**KIRKLEES METROPOLITAN COUNCIL  
INVESTMENT & REGENERATION SERVICE**

**DELEGATED DECISION TO DETERMINE PLANNING APPLICATIONS**

Reference No:	<b>2023/62/90988/E</b>
Site Address:	rear of, 3, East Fold, Skelmanthorpe, Huddersfield, HD8 9EZ
Description:	Erection of detached dwelling
Recommending Officer:	Nina Sayers

**DECISION - REFUSED**

Proposed Plans and Elevations

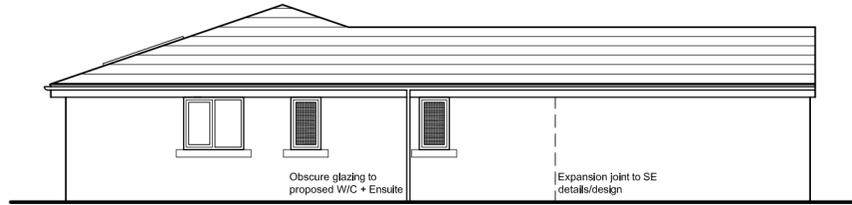
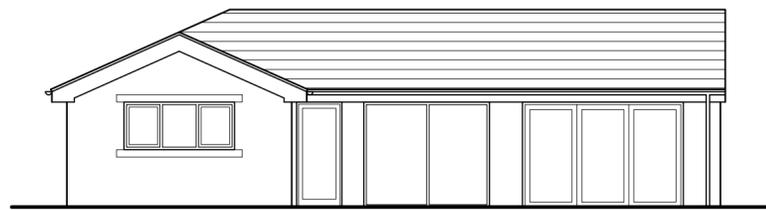
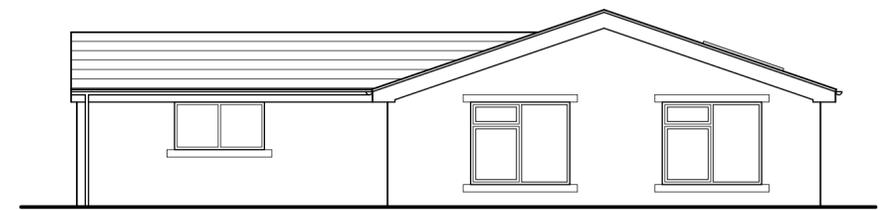
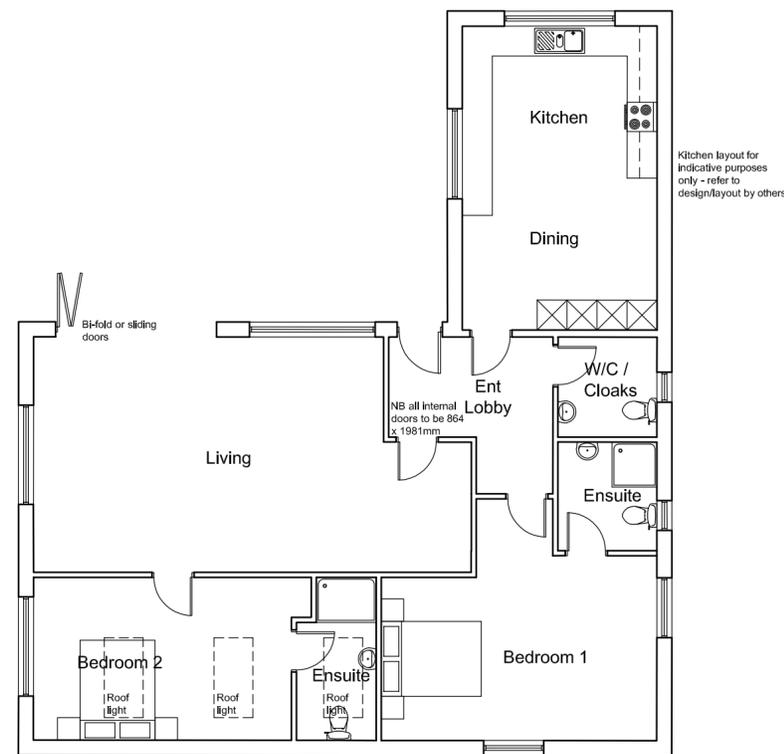
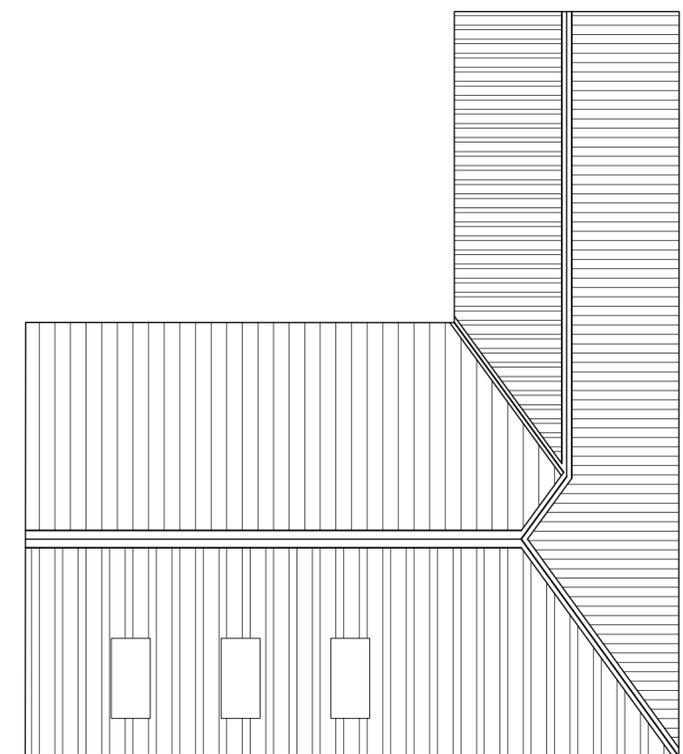
In terms of design, the proposed dwelling would comprise an L-shaped, bungalow with a hipped roof form, finished in natural stone under slate roofing. The surrounding area is a mixture of single and two-storey properties, so there is not prominent roof form. The properties are predominantly finished in similar materials to the proposed dwelling. Notwithstanding concerns regarding the principle, the proposed design is considered to not cause any harm to the visual amenity of the wider area.

No.2 East Fold is located due south of the application site. There would only be one opening on the southern elevation of the proposed dwelling, which would be set in ~4.1 metres from the shared boundary. No.2 is set ~12.5 metres from the shared boundary. Whilst this would result in a separation distance of less than 21 metres, the proposed dwelling would be single storey and there would be significant planting along the boundary that would prevent any significant overlooking, overbearing or overshadowing to neighbouring or future occupiers. A site section would be beneficial in terms of demonstrating the relationship. Details of boundary treatment would need to be secured by condition to preserve residential amenity should this application be approved.

The proposed dwelling exceeds the minimum recommendations as set out within the NDSS for such a dwelling, and the proposed garden is considered to be a good size for a dwelling of this scale.
